1865 WOODMOOR DRIVE

LANDSCAPE PLAN

PPR1830

1 DECIDUOUS TREE PLANTING DETAIL SCALE: NOT TO SCALE

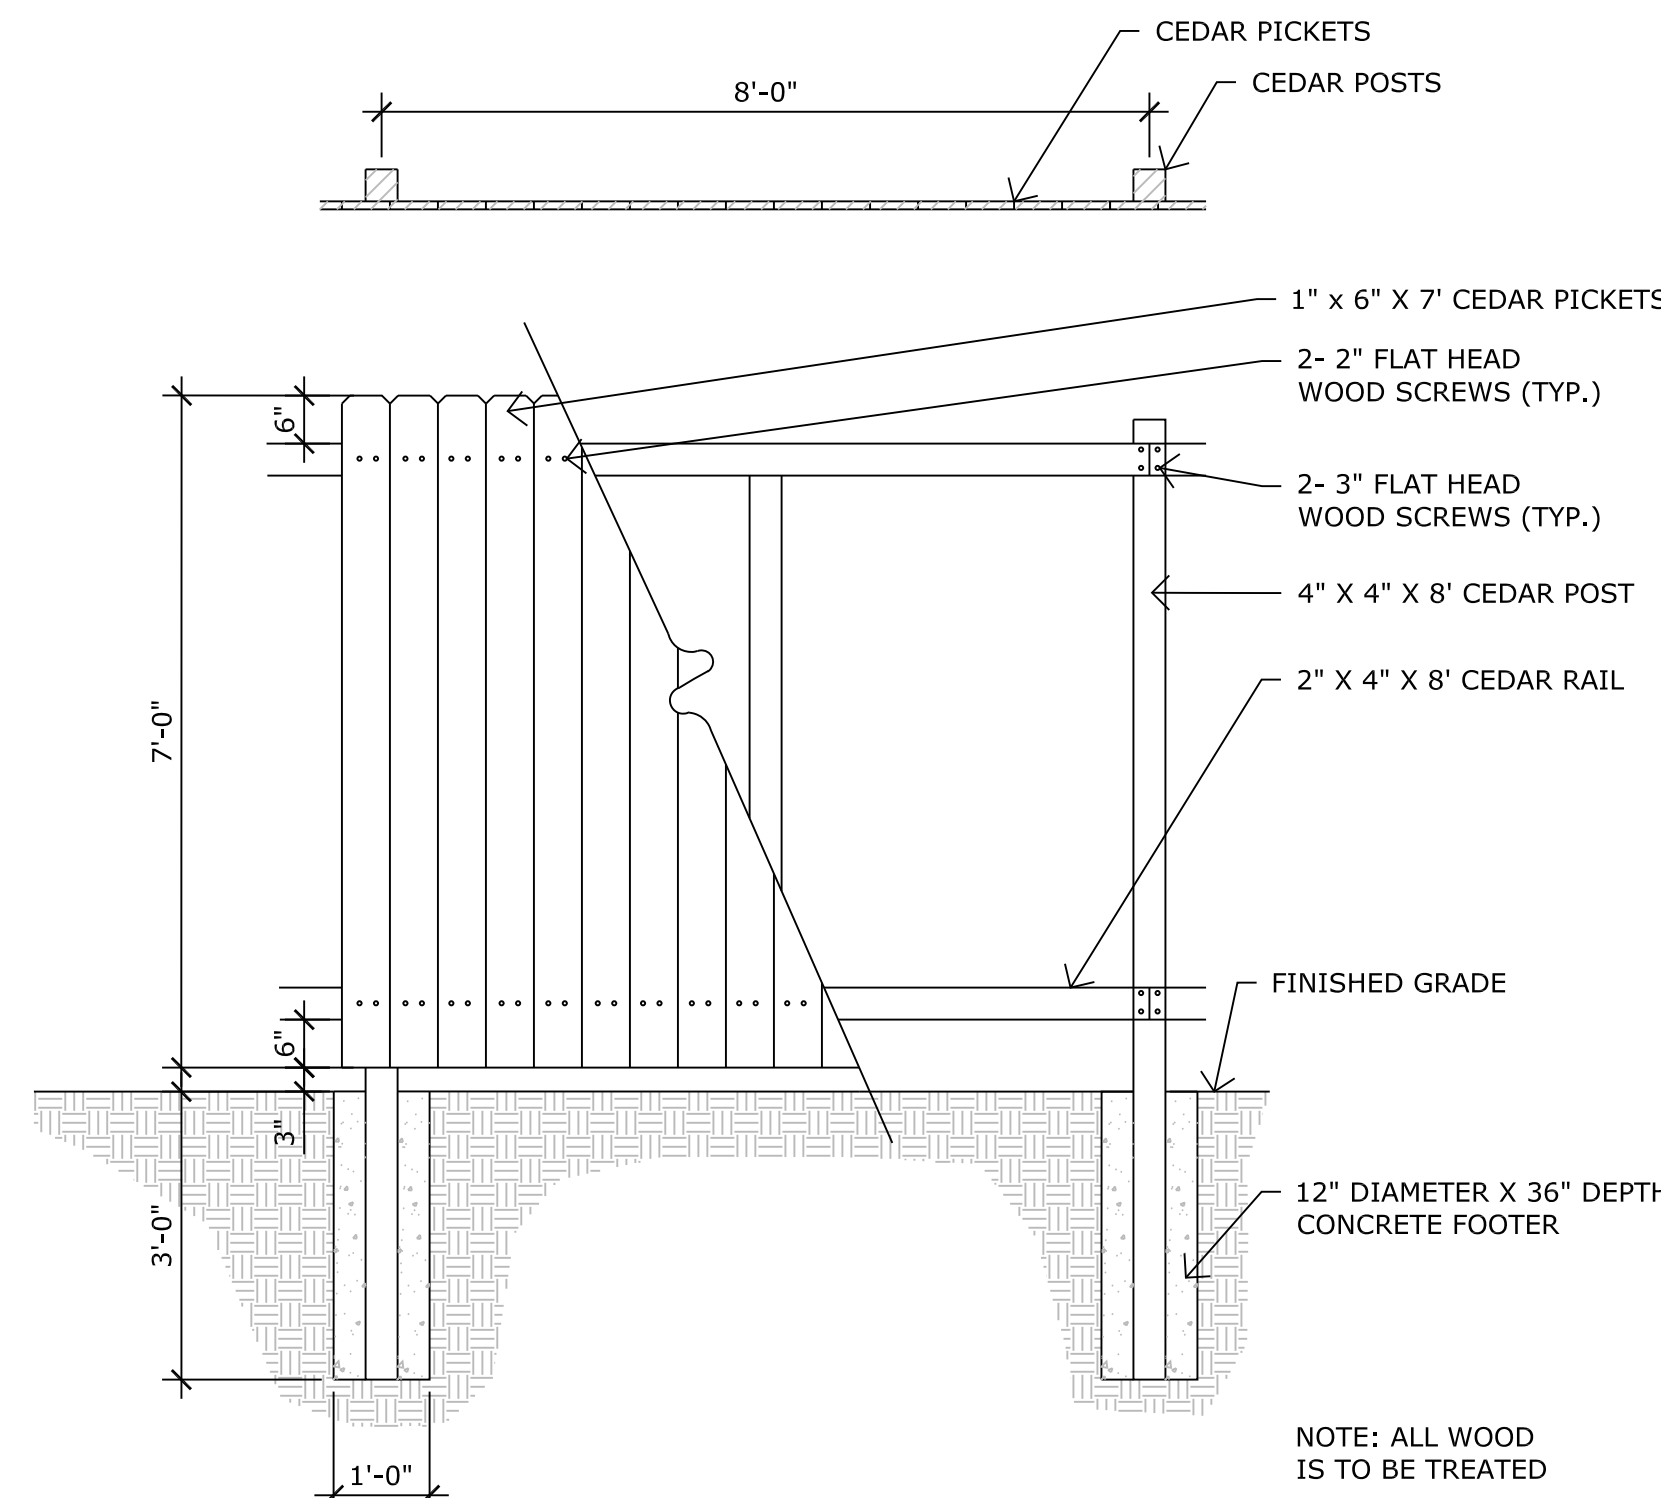
There is no height shown on the details page 2 to indicate if the shrubs meet the 3' LDC requirement outlined in the Chapter 6 overview provided. Please add a height so that we may confirm compliance.

Please provide a side elevation of the trash enclosure.
